GOVERNMENT ARCHITECT NEW SOUTH WALES

MARTIN PLACE OSD DRP – SESSION 13 05.05.20

SSDA Condition B13 –Through Site Link

MARTIN PLACE OSD DRP
SESSION 16 20.10.20

Level of design finish

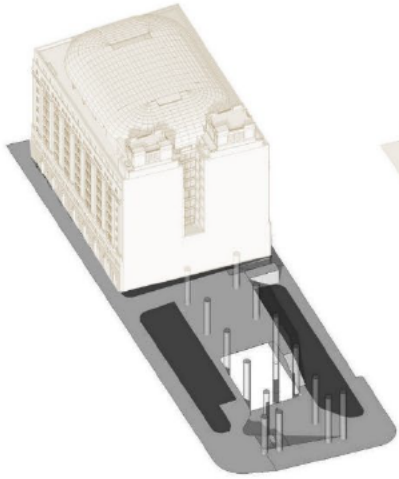
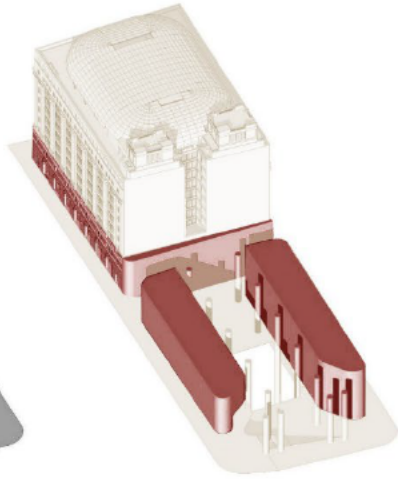
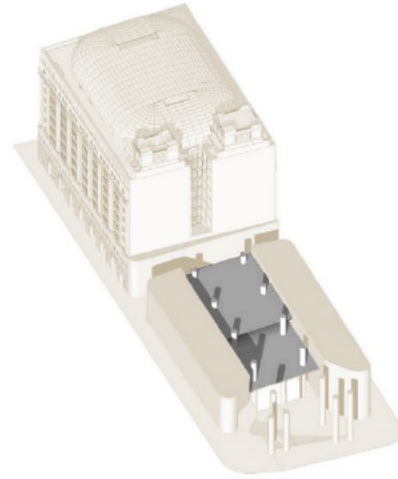
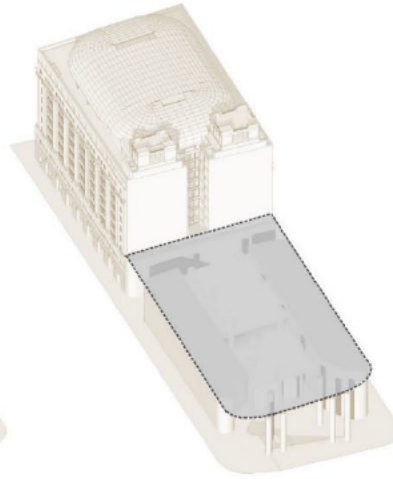
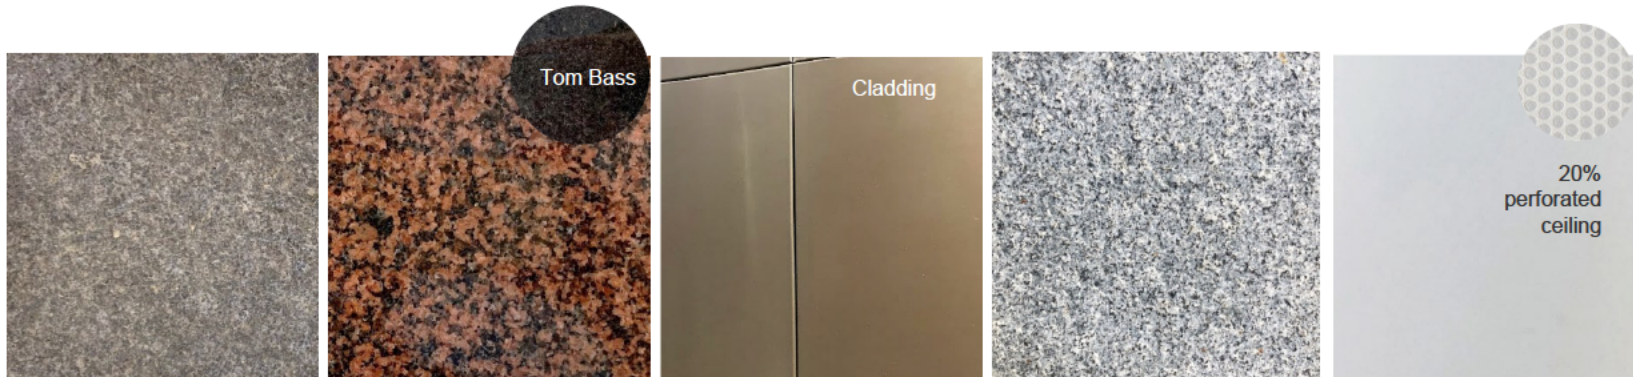
- e) Materials and Finishes
 - The panel is supportive of the proposed materials palette presented in DRP 14 featuring further refinement of specifications to include greater richness and patina in selected materials

- The proposed continuation of Austral Black Granite paving through the site and in the public room with a varied bond pattern is supported
 - The proposed lighting design for the Through Site Link and specialist lighting for artworks is supported
